FFERM WYNT ALLTRAETH MONA / PROPOSED MONA OFFSHORE WINDFARM

**CYFEIRNOD YR AROLYGIAETH GYNLLUNIO / PLANNING INSPECTORATE
REFERECE: EN010137**

**RE: NATURAL RESOURCES WALES' DEADLINE 4 ISSUE SPECIFIC HEARING 3:
POST HEARING SUBMISSIONS**

Seascape Character Types in the Amlwch and Cemaes SCA.

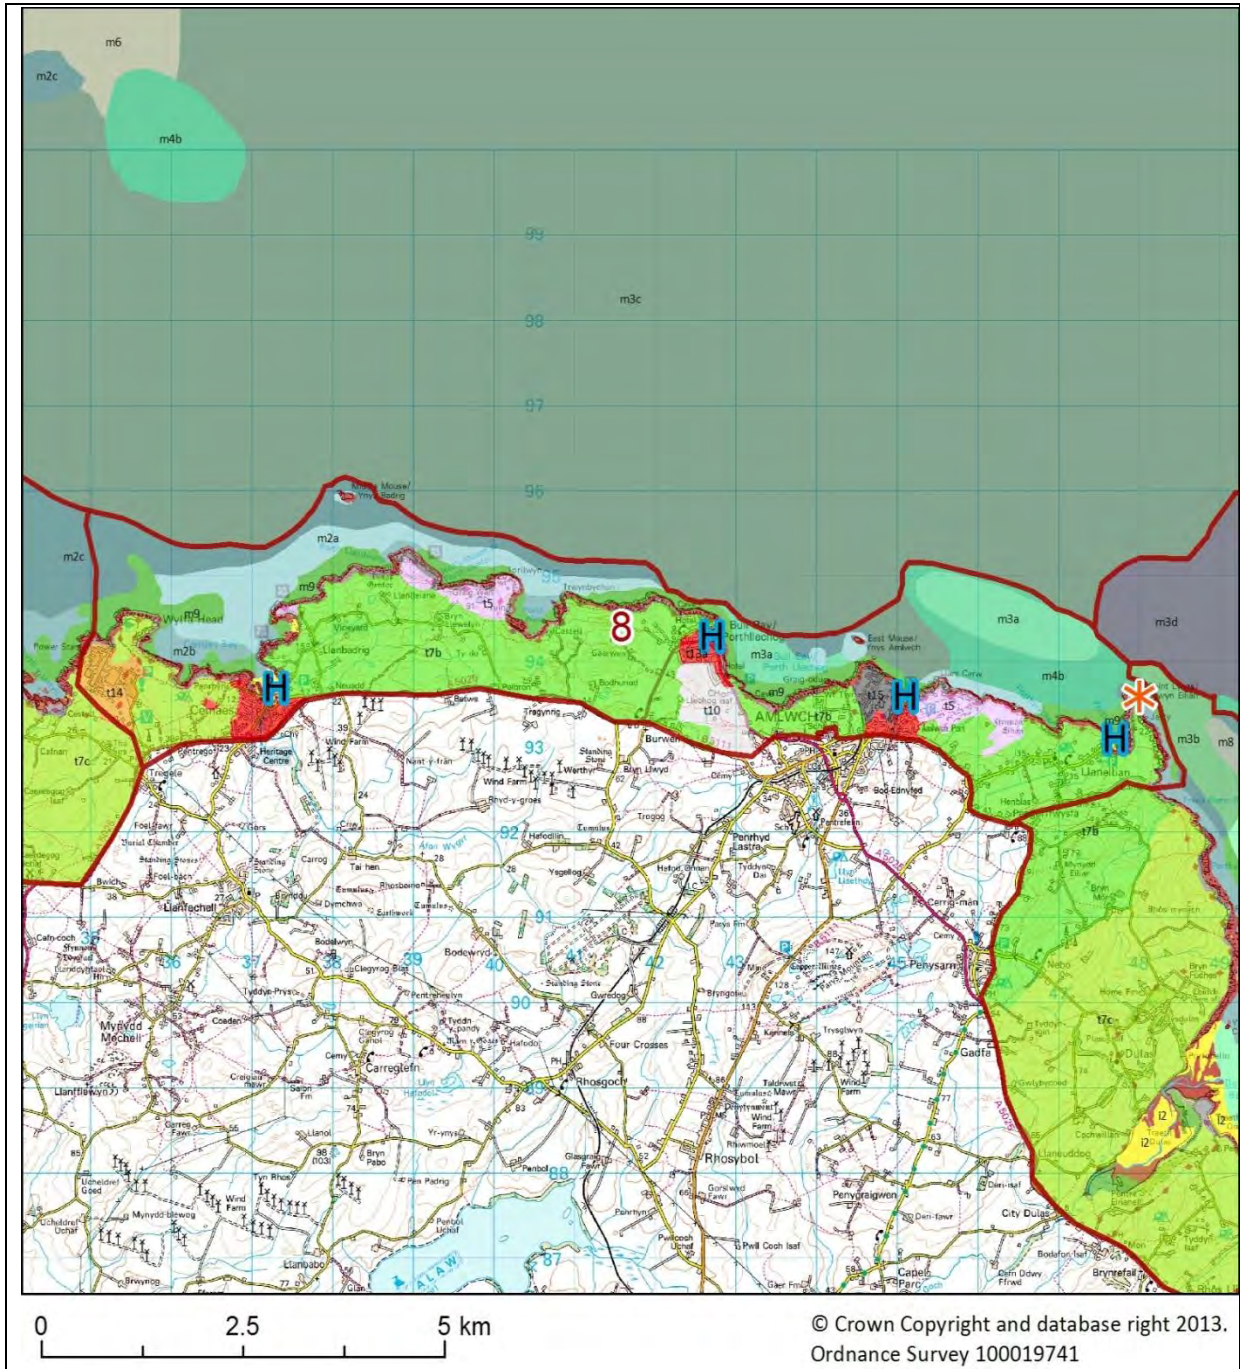
- (6) One of the areas particularly affected by the application proposals is SCA 8: Amlwch and Cemaes. The description of this character area highlights valued aspects including the open views seawards to the north, the wild qualities of the rocky coast and seascape, and the sense of remoteness and wildness particularly in areas of coastal heath.

(10) When having regard to all these factors it can be appreciated that there will be significant effects from the application proposals. Our assessment is that the magnitude of change to the special characteristics and qualities of the Seascape Character Assessments (SCAs) on IoA would be medium and the effect up to moderate/major adverse and significant at locations within for example SCA8 of the Anglesey Seascape Character Assessment.

Figure 6
Buffers to National Parks and AONBs off North Wales:
Medium magnitude of effect

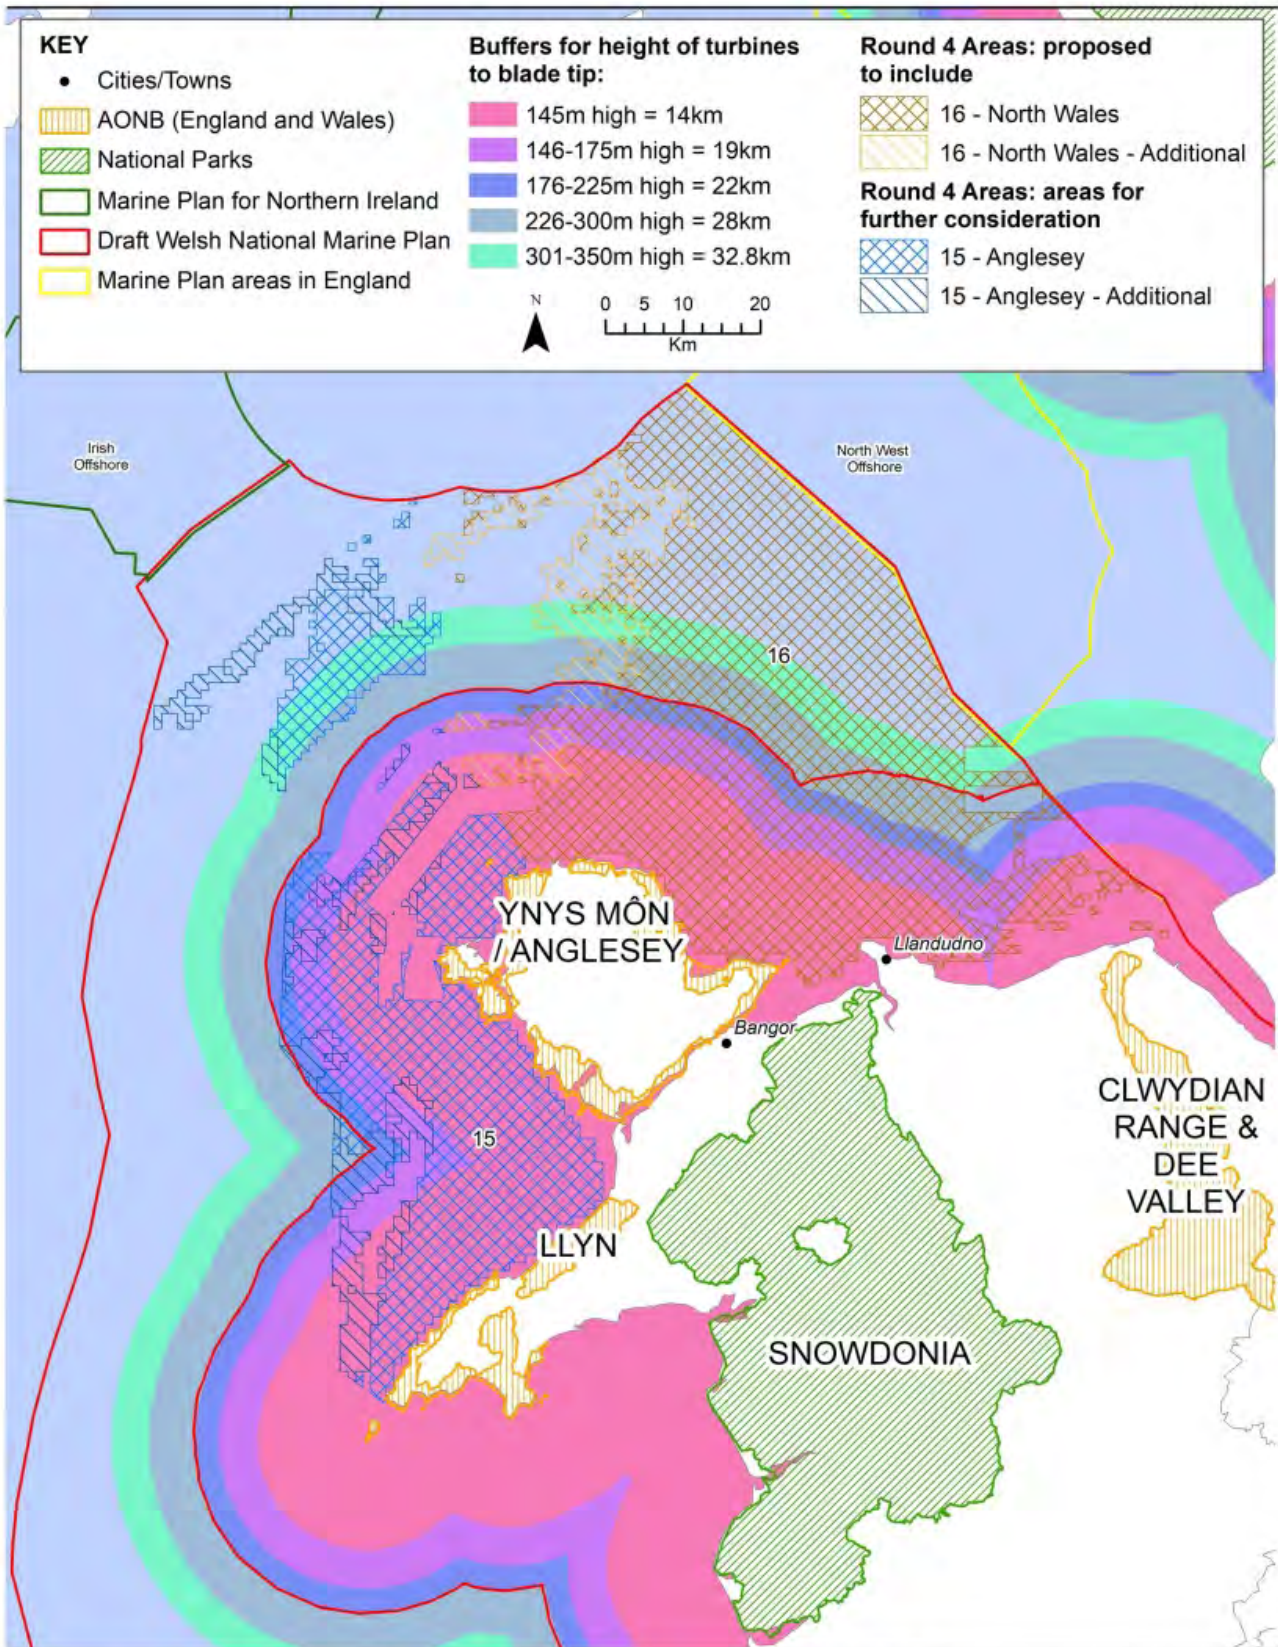
- (i) Turbines between 300-350m in height typically have a low magnitude of effect, resulting in a moderate and potentially significant effect on high sensitivity receptors who are up to on average 44km in distance from the turbines;

- (ii) Turbines between 300-350m in height typically have a medium magnitude of effect, resulting in a moderate/major and therefore significant effect on high sensitivity receptors who are up to on average 33km in distance from the turbines.

- (4) These numbers are only a guide, and they do not fully represent the greater impacts of schemes taller than 350m such as the application (with a 364 blade tip height), nor do they provide an upper limit for these effects. But they illustrate the distances where significant effects – as shown by evidence – may occur or are expected to occur. They also support our advice that 29km – which is the distance of the array offshore from the IoA - should not be assumed to be too far for significant impacts to arise, when what is in issue is the impacts of turbines with a 364m blade tip height.
